Minutes

Purpose:	Summary of Consultation Meeting Between Ku-ring-gai Municipal Council (KMC) Representatives & the Project Team for the Roseville College New Sport and Wellbeing Centre Development (the proposed development)
Meeting Location:	Ku-ring-gai Municipal Council Administration Centre 818 Pacific Highway, Gordon NSW 2072
Development Site:	Roseville College, 27-29 & 37 Bancroft Avenue, Roseville
Meeting Date:	16 July 2020
Our Ref:	20676A.17KC_KMCMinutes200716
Application Number:	State Significant Development (SSD) – Ref: SSD-9912

On Monday 3 August 2020, SS provided the following comments to KC via email:

Sheet: EPM05-DA-101

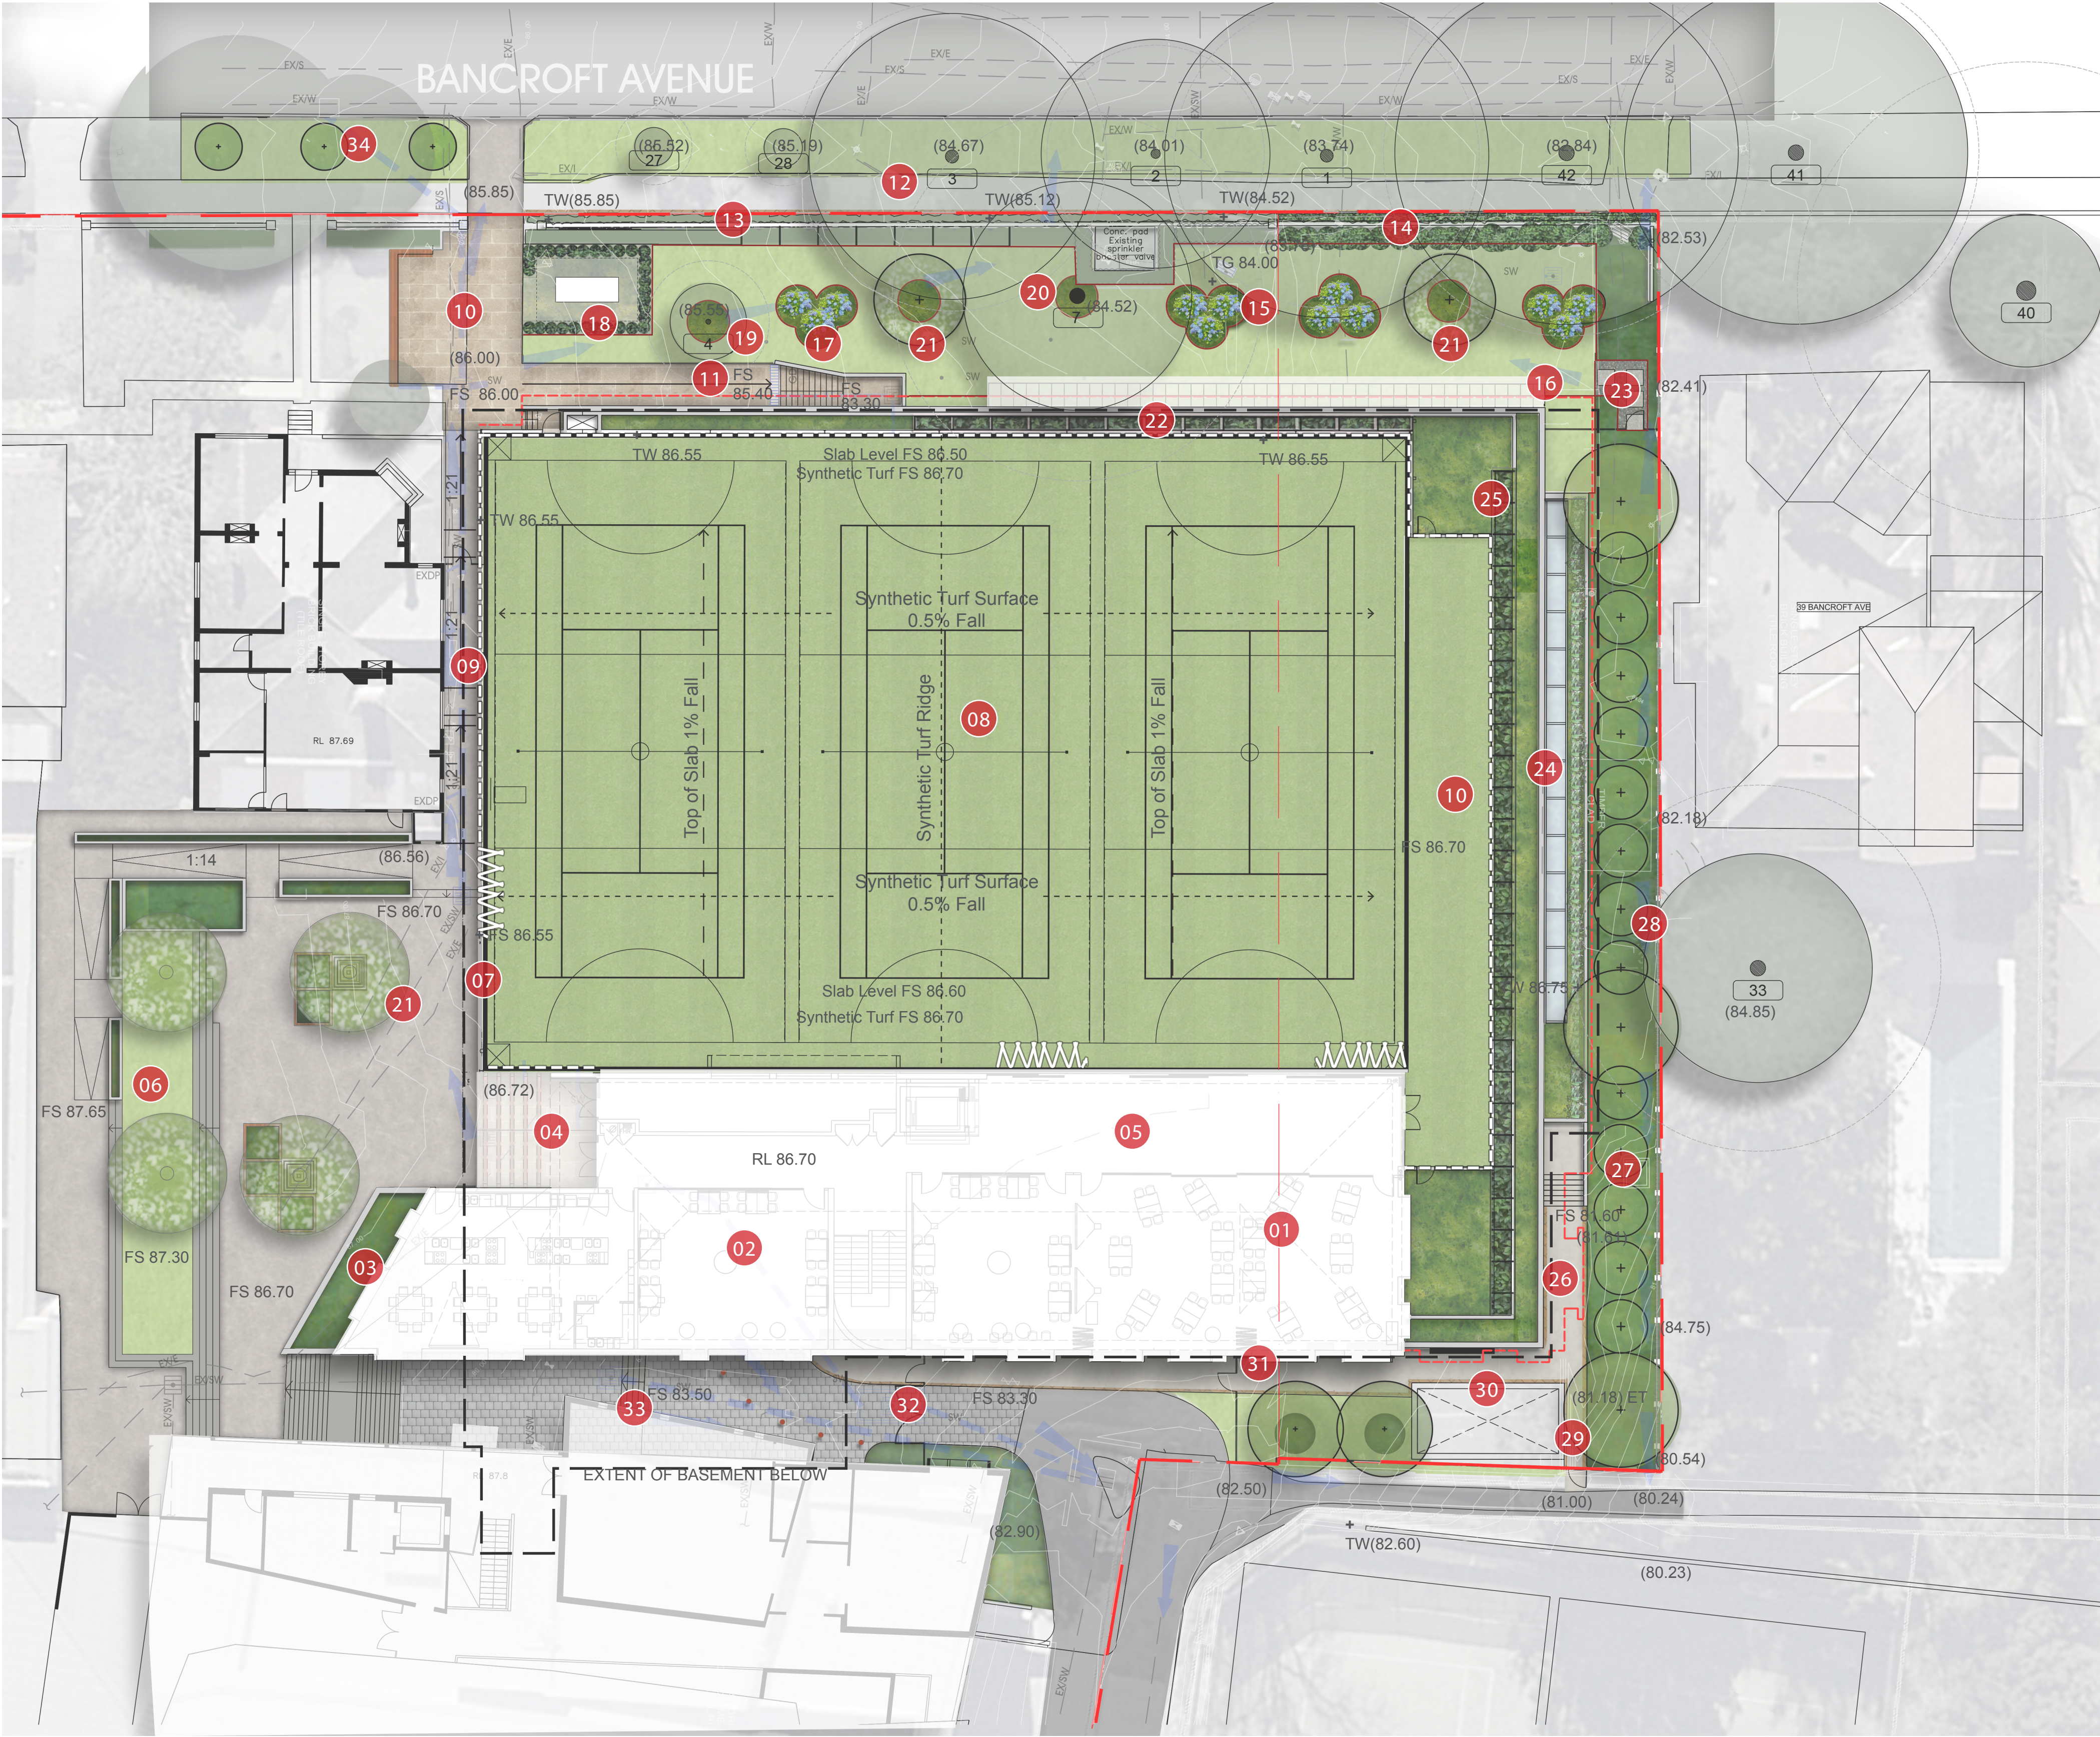
Amended plans 02 Level 1–Plan Rev G dated 15/06/20 and 03 Level 2–Plan Rev G dated 15/06/20 indicate a development setback of 5.6m to the outer northern wall of Level 1. The applicant has calculated this as an encroachment of 14.3%. The development encroachment has been incorrectly calculated and is greater than that shown for the following reasons:

1. The TPZ (Tree Protection Zone) has been incorrectly calculated. The trunk diameter is 800mm which has a TPZ of 9.6m when assessed against AS4970-2009 Protection of Trees on Construction Sites. The applicant has incorrectly identified a TPZ of 8.4m. Therefore the TPZ is greater than that shown, and therefore the development encroachment and potential impact is greater than that depicted at 14.3%.

2. The shown development encroachment has not considered a proposed retaining wall that runs parallel to the northern façade. The retaining wall is setback 3.0m from Tree 7 and at the outer edge of its SRZ (structural root zone) further reducing the development setback within the tree's root plate and increasing potential tree impact through root severance. The tree's RL is identified as 84.54, with the proposed ground level/entry shown as 82.9, resulting in an excavation greater than 1.6m. It is likely the excavation

- *The proposed retaining wall and level changes north of the building should be deleted, and existing levels and grades retained to the greatest extent possible within the TPZ of 9.6m. As per AS4970-2009 (3.3.2) it is recommended the area of encroachment be compensated elsewhere and contiguous with the TPZ.*

- *It is recommended the area of encroachment be minimised. This can be achieved with the reduction in width of the northern side pedestrian path, currently proposed at approximately 2.4m wide. This path can be significantly reduced in width.*

- *The planting of an additional Cedrus deodar/Himalayan Cedar within the Northern setback is supported and an appropriate species for the HCA and streetscape character. Its location however should be amended so that it does not conflict with the proposed sub-station to ensure its long term viability.*

- *The location of the proposed substation within the Bancroft Ave site frontage is uncharacteristic of the established residential streetscape character, and reduces the available unrestricted deep soil landscape area within the Bancroft Ave site frontage for the provision of replenishment tree planting. It is recommended the substation be relocated to the Recreation Ave site frontage which has a more commercial character where there is a dominance of the built form and away from residential properties.*
